Rosefield Solar Farm

Written Summary of Applicant's Oral
Submissions at Compulsory Acquisition
Hearing 2

EN010158/APP/8.34
Deadline 5
July 2026
Rosefield Energyfarm Limited

TITLE:
FIGURE 3.7: INDICATIVE CABLE CROSSINGS AND
CABLE CORRIDORS

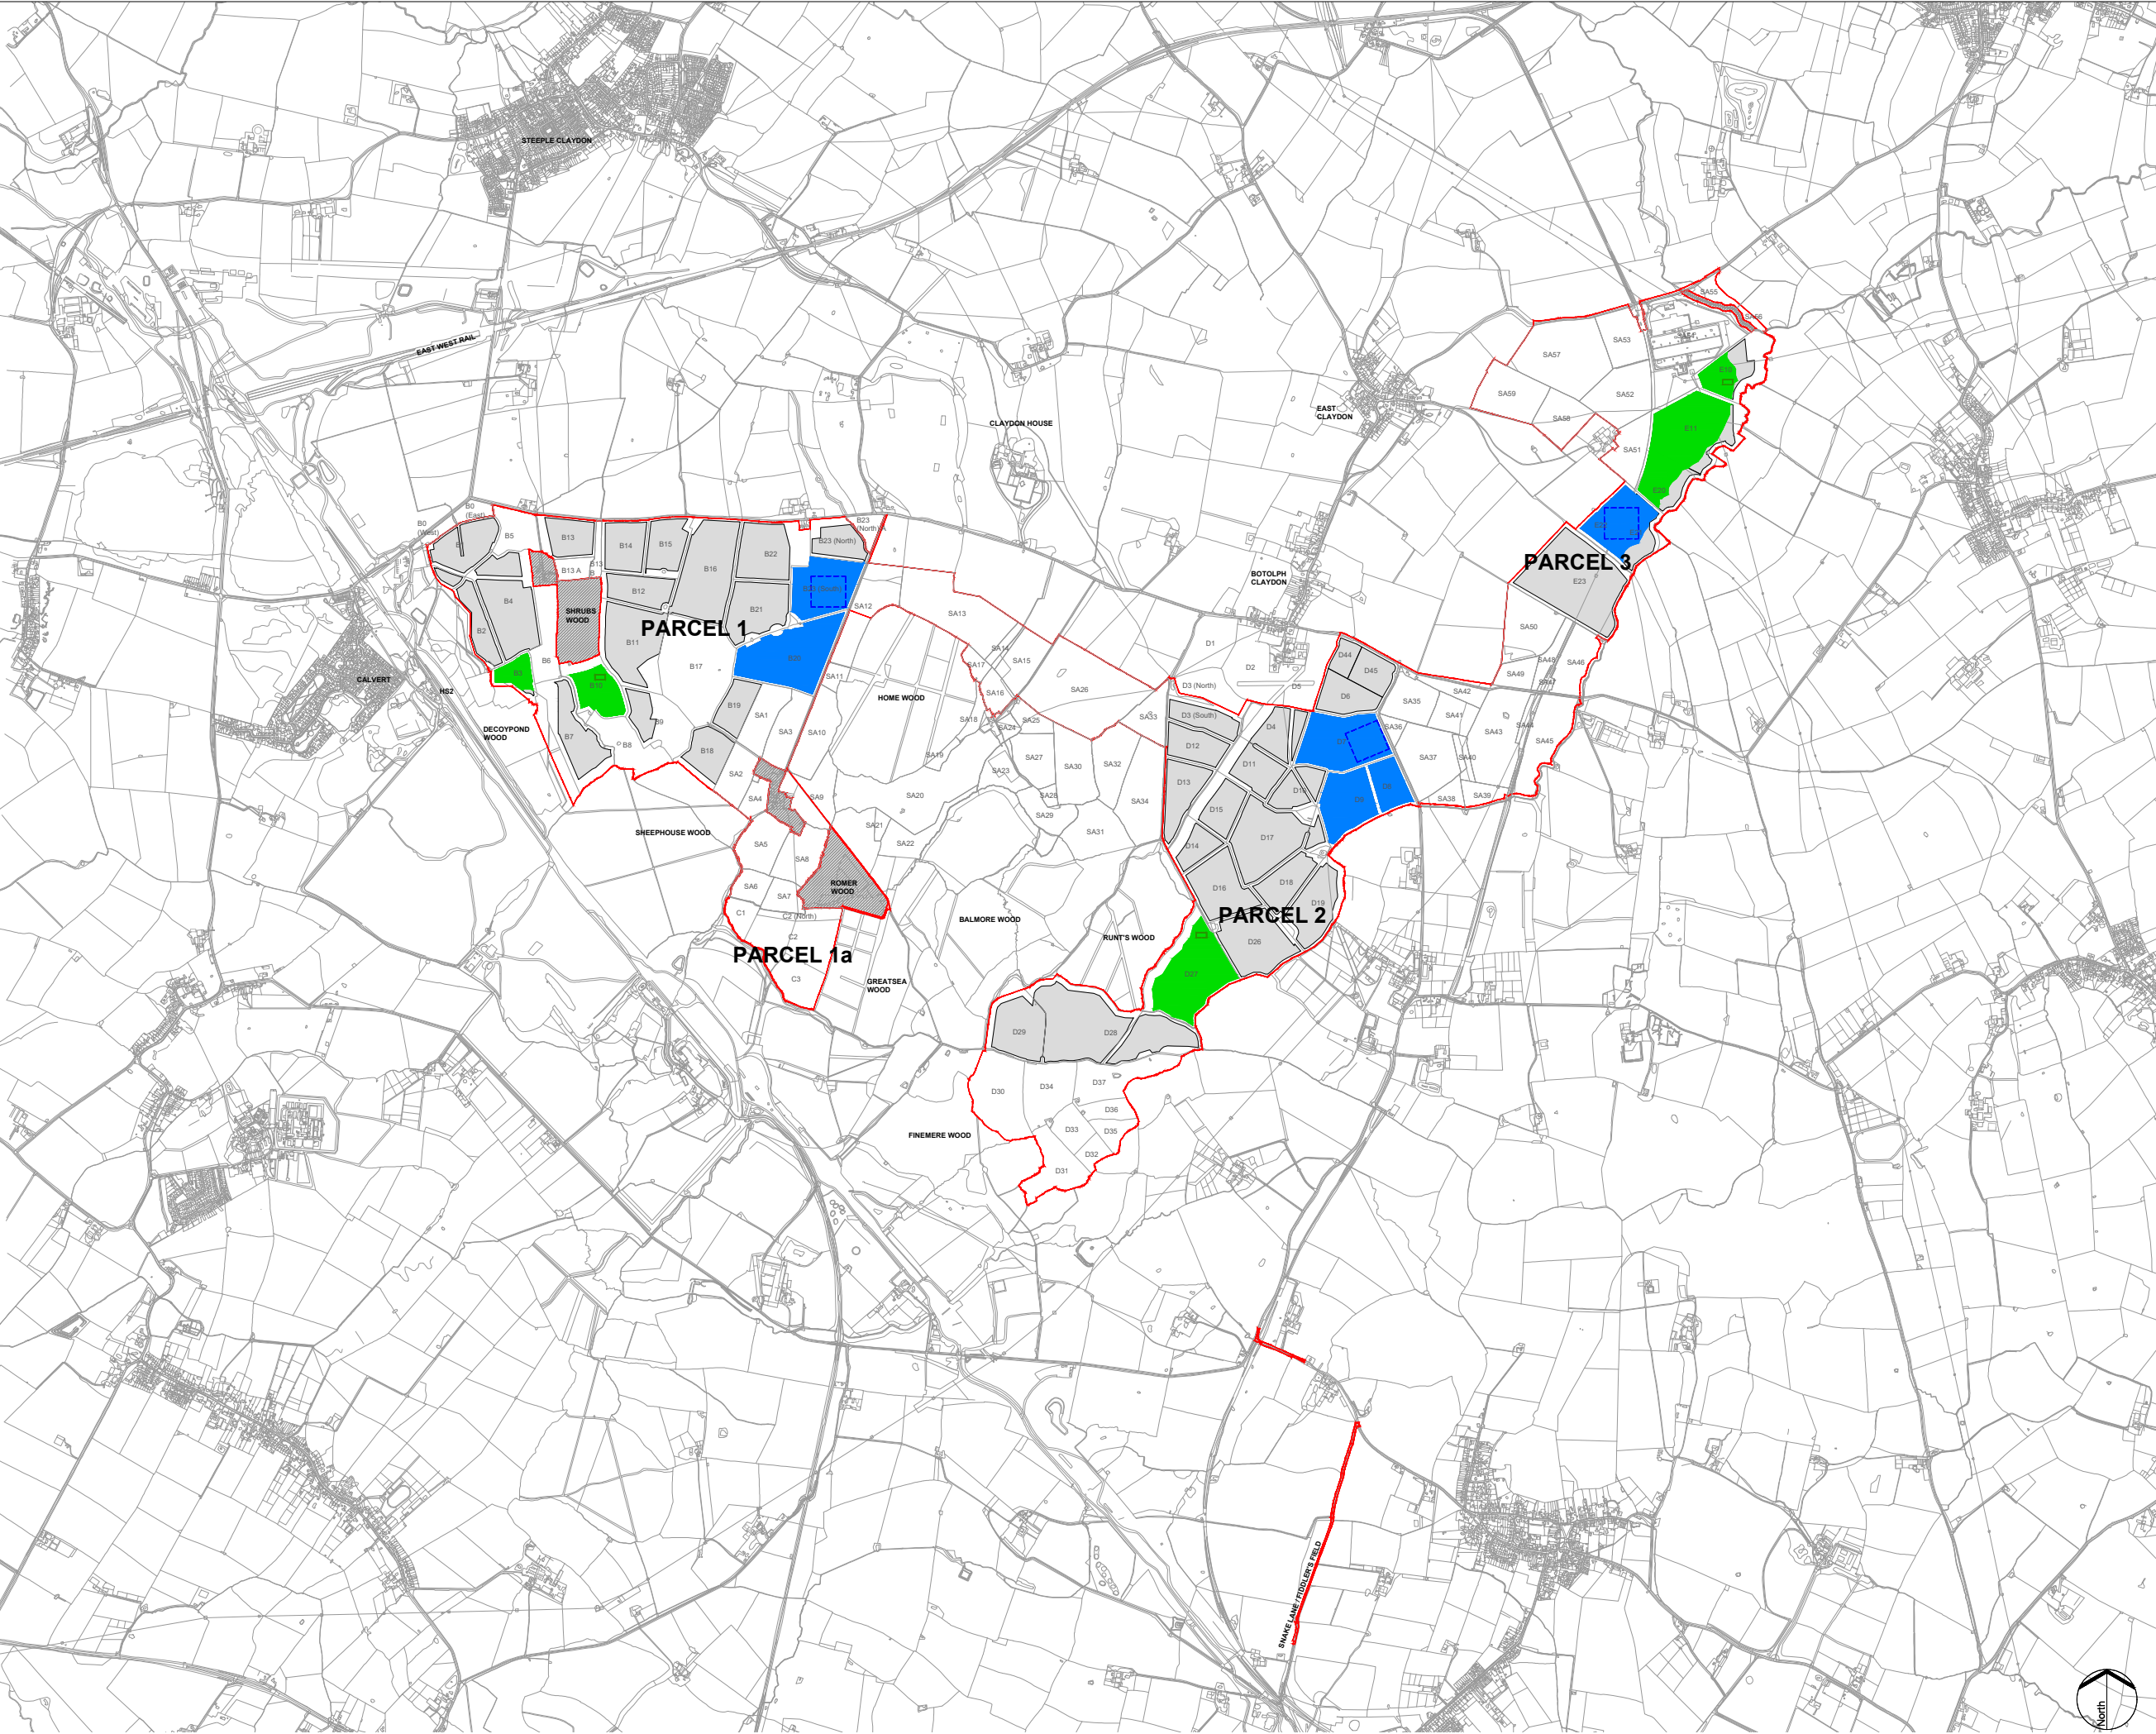
7	By reference to Figure 3.7 in [REP4-043], explain why there are two cable runs	Applicant	5	Figure 3.7 of Environmental Statement Volume 3 Proposed Development Description Figures 3.1 – 3.14 [REP4-043] shows an indicative Rochdale Envelope area where cable runs could possibly be located, providing some flexibility for the cable alignment and positioning

#	Action Point	Directed to	DL	Applicant's Response
	indicated and whether there could be a single run.			within the fields. It may be possible at detailed design stage to rationalise the cable runs to only use the most eastern runs and remove the western zone that is marked up for the cable route. This will depend on final cable design and alignment (which will comply with relevant Design Commitments [EN010158/APP/5.9.7] including commitments securing the maximum width and depth of cable trenches for Work No. 6 and Work No. 7), but detailed design will seek to reduce the area needed for cable to as small as possible. It is unlikely the western cable run on its own will provide enough space for all the required cable runs to connect from Parcel 2 to Parcel 3 so the eastern run would not be able to be fully removed at this stage, it is more likely that this is the western section.
8	Provide a plot-by-plot analysis of which plots of land the Prestons believe fail the CA tests and an explanation as to why.	Prestons	5	N/A for the Applicant to respond.
